TECHNICAL NOTE

WINGS NURSERY, LIDSEY ROAD, WOODGATE, WEST SUSSEX

Response to West Sussex County Council Highway Comments.

Ref: ADMA/17/3711s

Plan No:	Job No:	Date:	Scale:
Plan 01	3711	June 2017	NTS
Drawn By:	Checked By:	Approved By:	Rev:
SMO	ALB	PMR	-

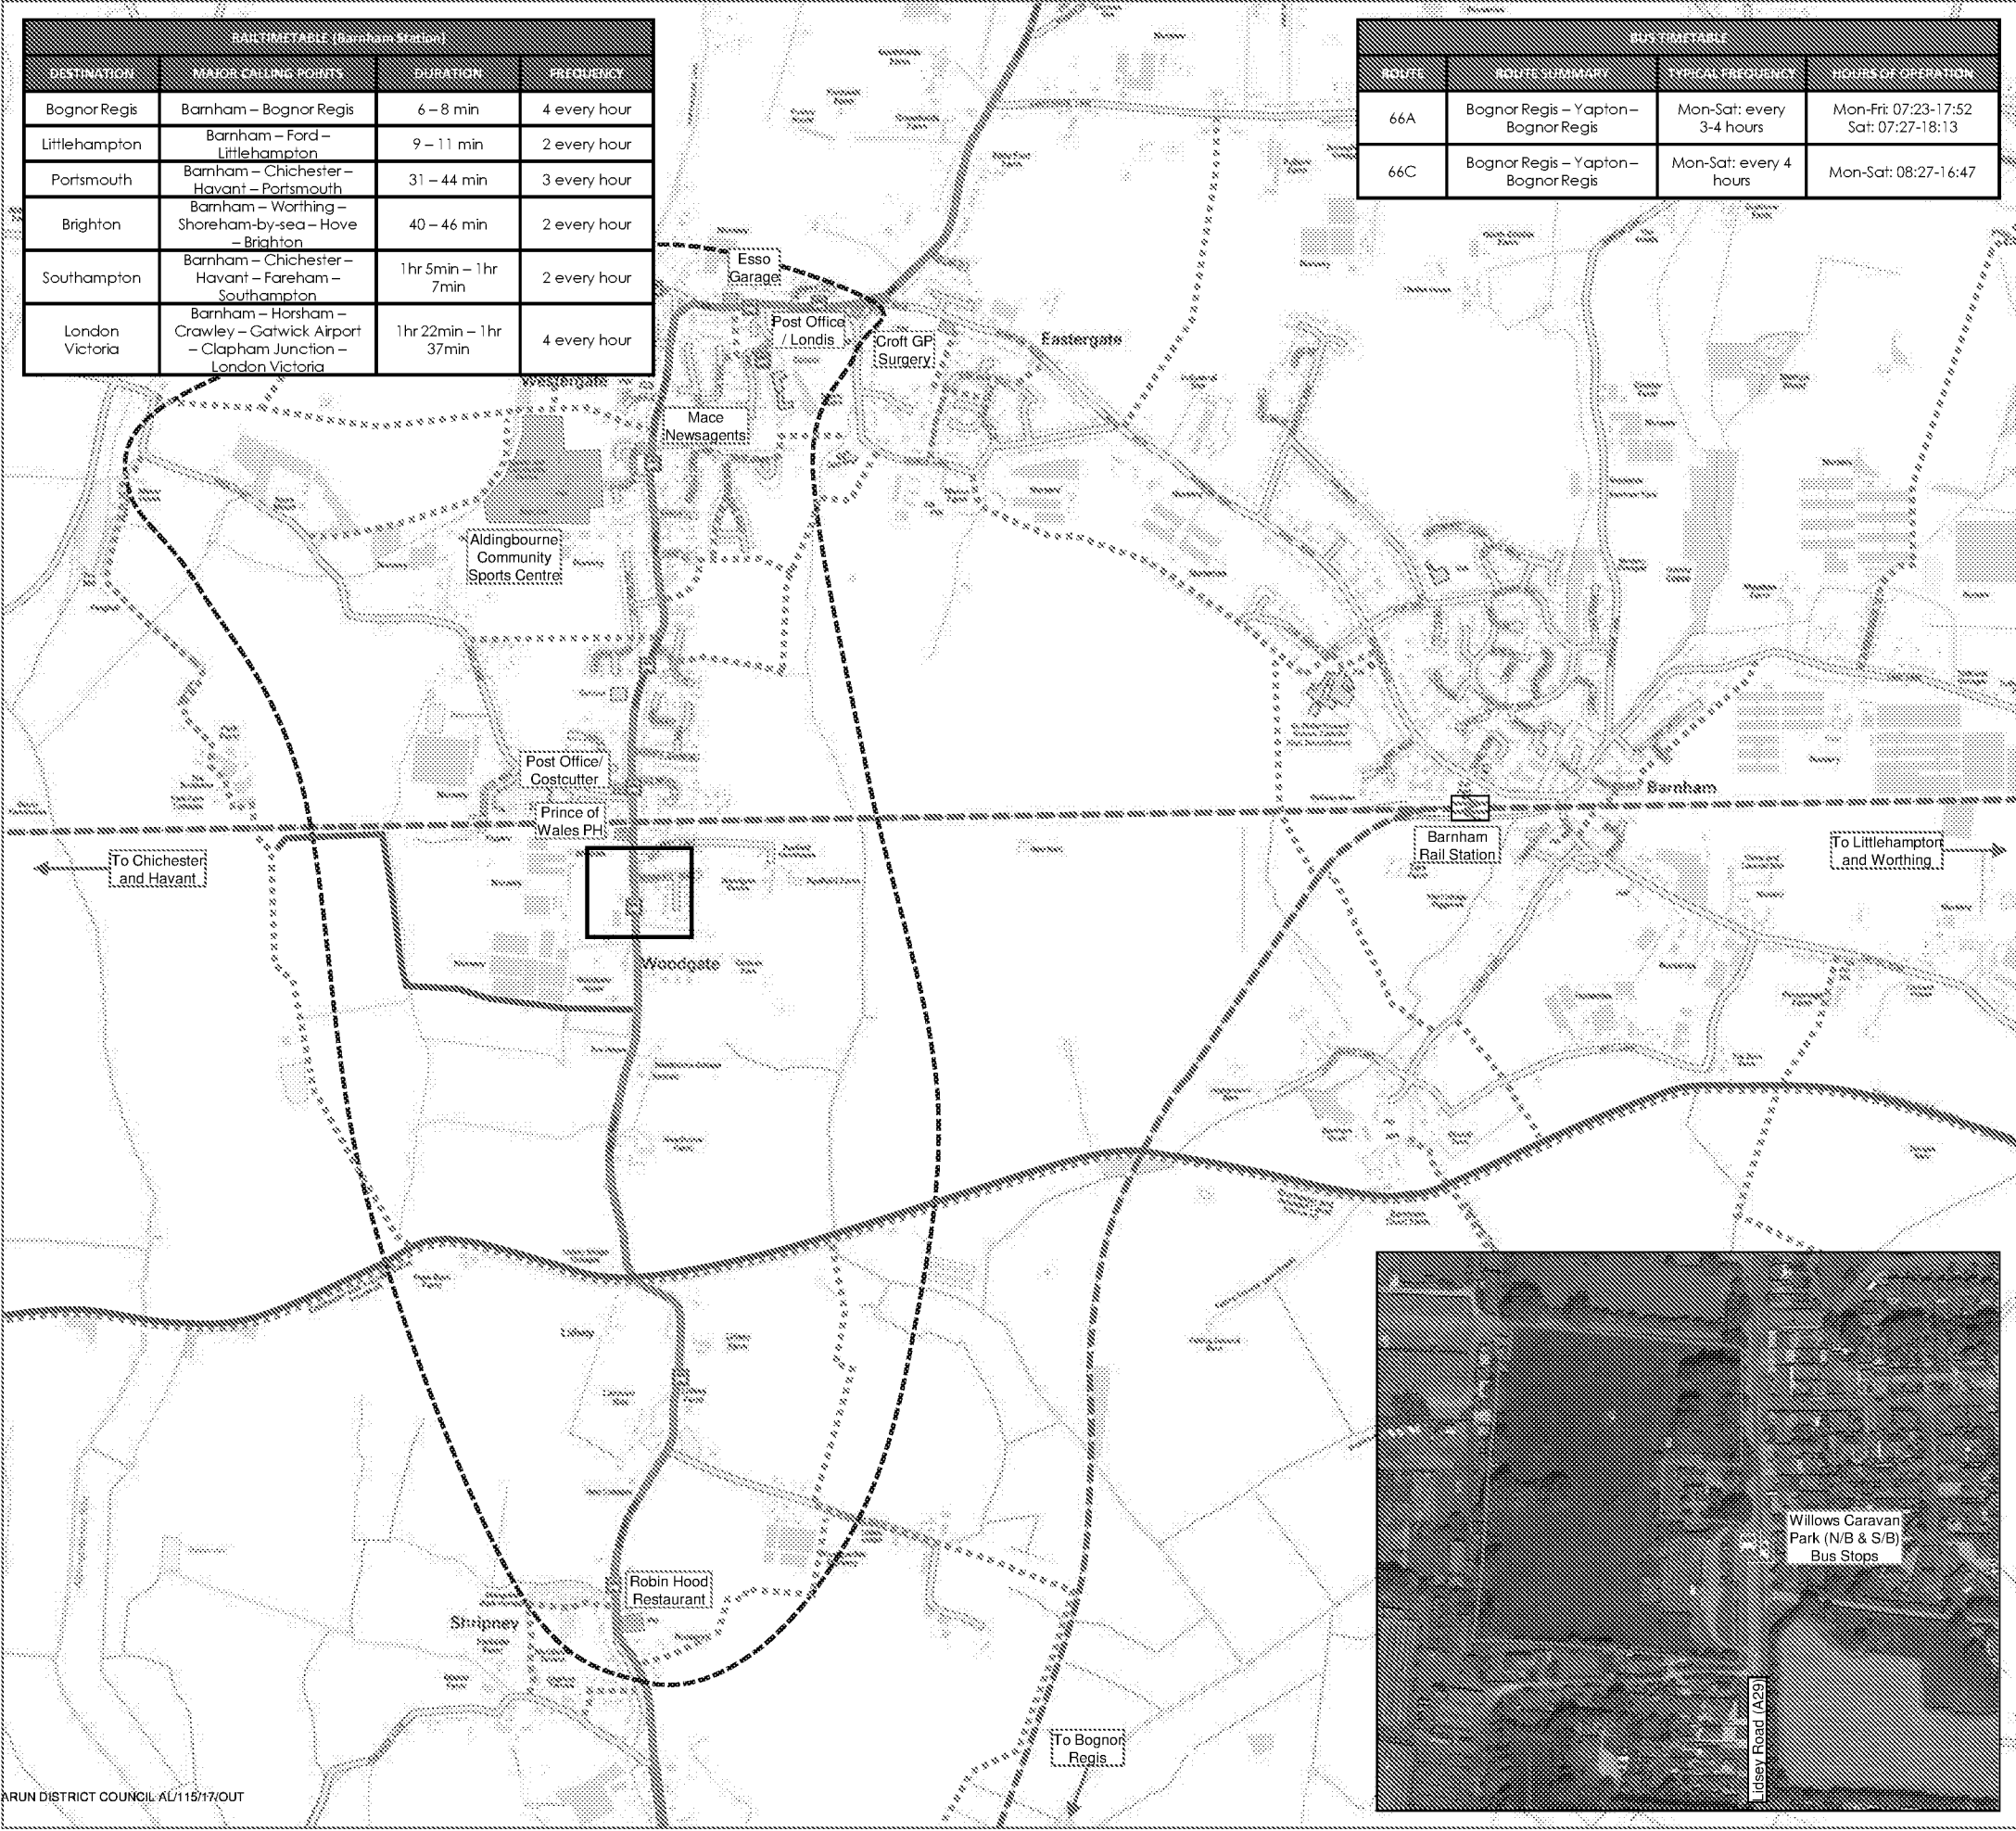
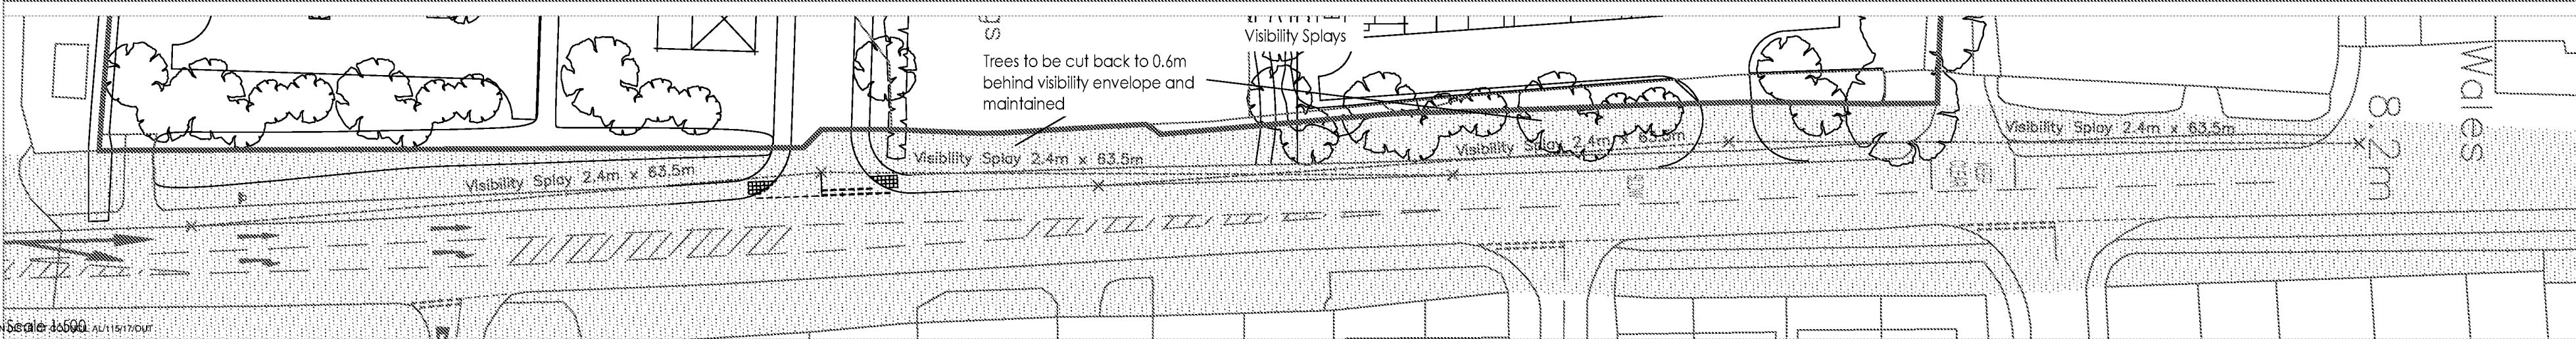
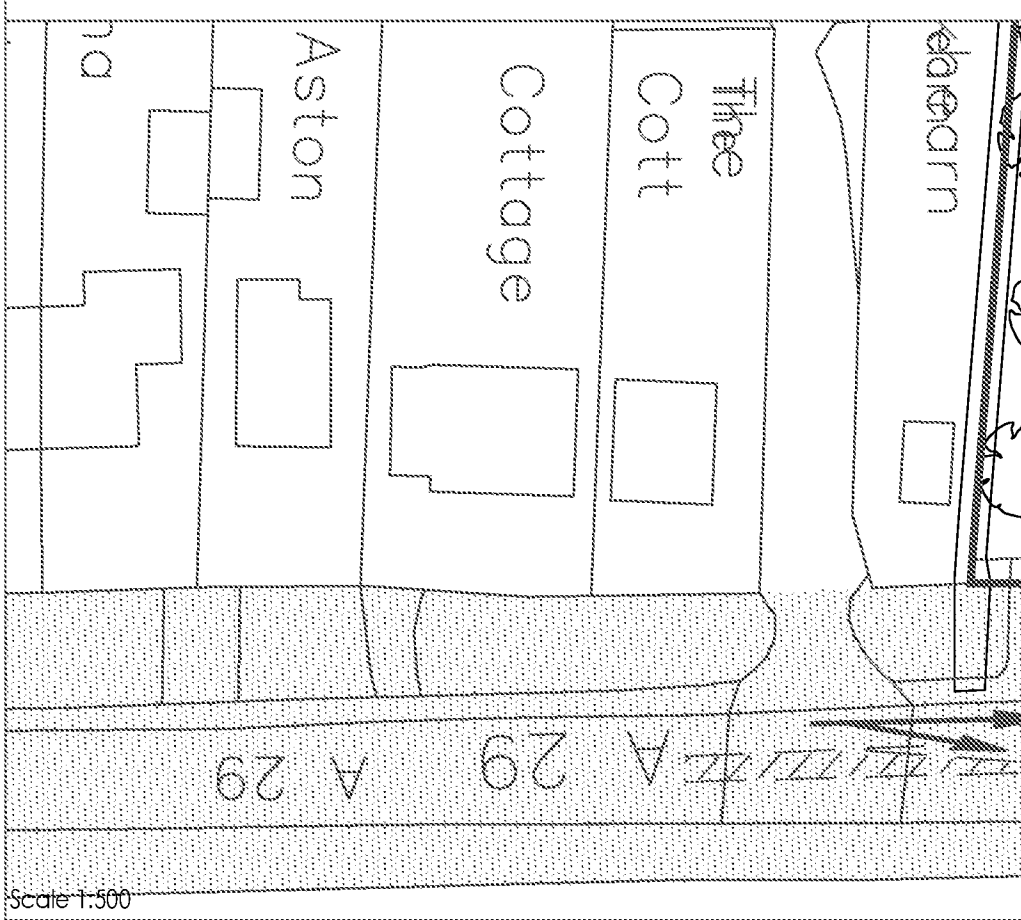
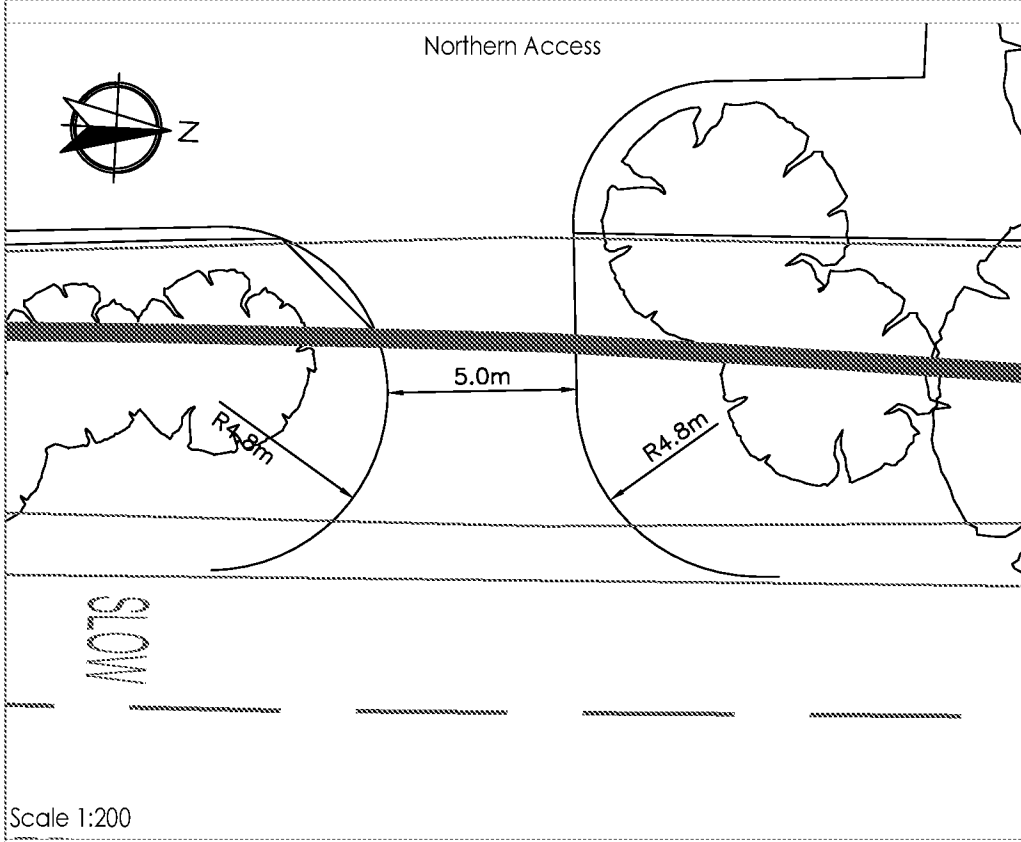
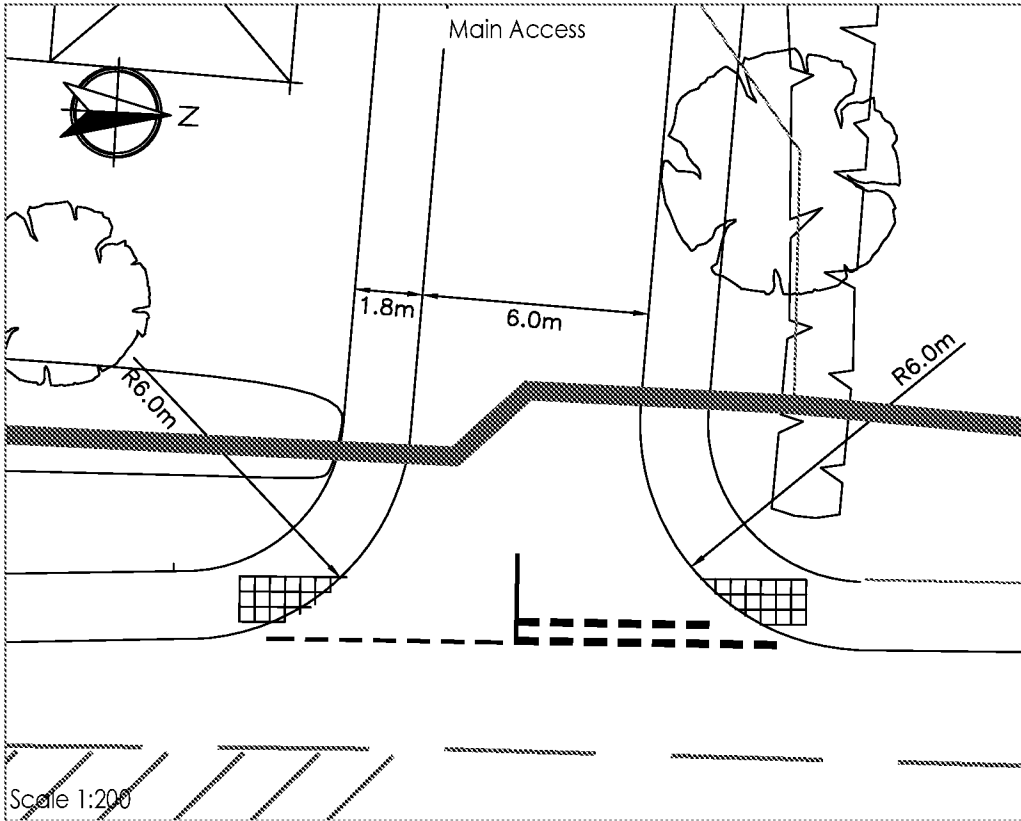
The development site is located in the village of Woodgate which forms the southern part of an almost continuous ribbon development northwards along the A29 and eastwards along the B2223 comprising the villages of Westergate, Eastergate and Barnham. It is remote from existing major employment centres in Bognor Regis, Chichester and Littlehampton although there are a number of smaller local employment centres in the aforementioned villages. In terms of transport sustainability, the site is not well located being on the edge of the settlement boundary and remote from the nearest railway station at Barnham. The level of bus service passing the site is also limited and the main cycle and pedestrian routes are along the busy A29. Cyclists have to share limited road space with other traffic. Pedestrians have to walk adjacent to traffic along the main road – in places where footways are narrow – and have no assisted ways to cross the A29 which if provided, could provide some access opportunities to formal Public Rights of Way (PRoW) leading towards Barnham and its railway station.

Given the above, there is again conflict with the NPPF. The lack of suitable pedestrian facilities was identified previously by the Highway Authority in connection with the previous Woodgate Centre planning applications and reiterated at the subsequent Planning Appeals. This was acknowledged by the Inspectors when considering the latter.

- 2.21 In the immediate vicinity of the site the existing community is supported by convenience facilities, local schools, and leisure facilities. As demonstrated in Plan 01 (attached) the site provides pedestrian and cycle connectivity to these services. The applicant is happy to cooperate in providing crossing facilities as required by the LHA, where cost effective and the level of mitigation offered is justified.
